Our ref: AN/2025/137099/01-L01
Your ref: H18-0879-25
Date: 22 October 2025

Erection of 8 dwellings
Land Adjacent 39 Custom House Street, Sutton Bridge, Spalding, Lincolnshire, PE12 9UJ

Environment Agency position

Figure 3 – SFRA 2115 Residual Peak Depth Map

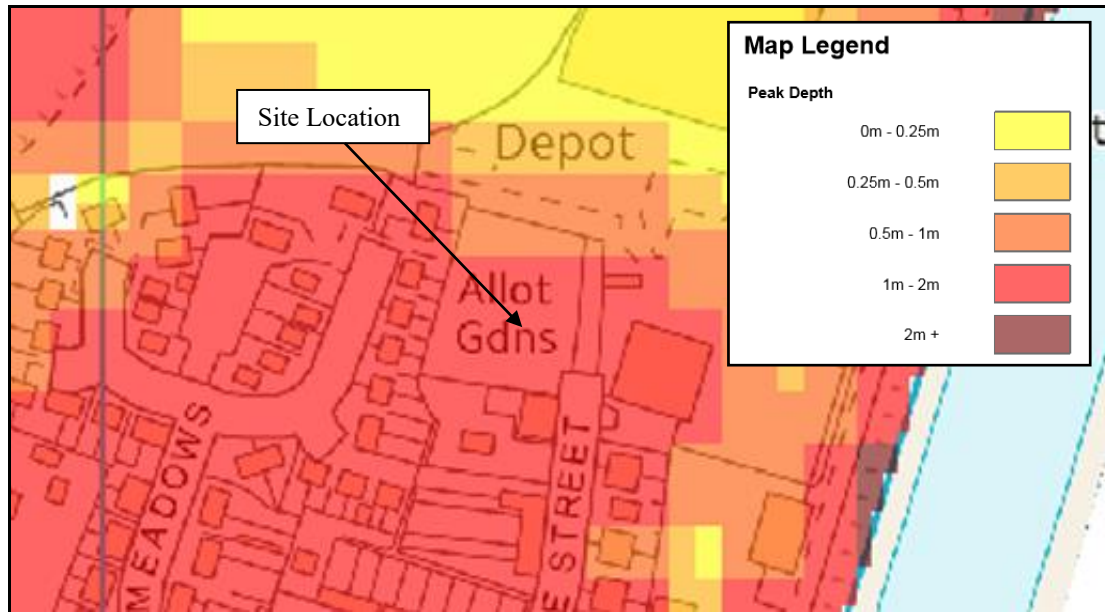
In particular, the FRA fails to fully explain how the predicted flood depth band of 1-1.6m has been derived. Appendix B of the South East Lincolnshire Strategic Flood Risk Assessment shows that the site could experience flood depths of 1-2m arising from a breach in the defences during a flood that has a 0.5% chance of occurring in any one year up to 2115.

The submitted FRA states 'Based upon the topographic survey and the depth and extent of flooding in Figure 3 the maximum flood depth during the 0.5% annual probability (1 in 200 chance each year) tidal event in 2115 is estimated to be between 1.0m and 1.6m'. We request that further explanation and reasoning on how the depth band has been derived is provided in the FRA.
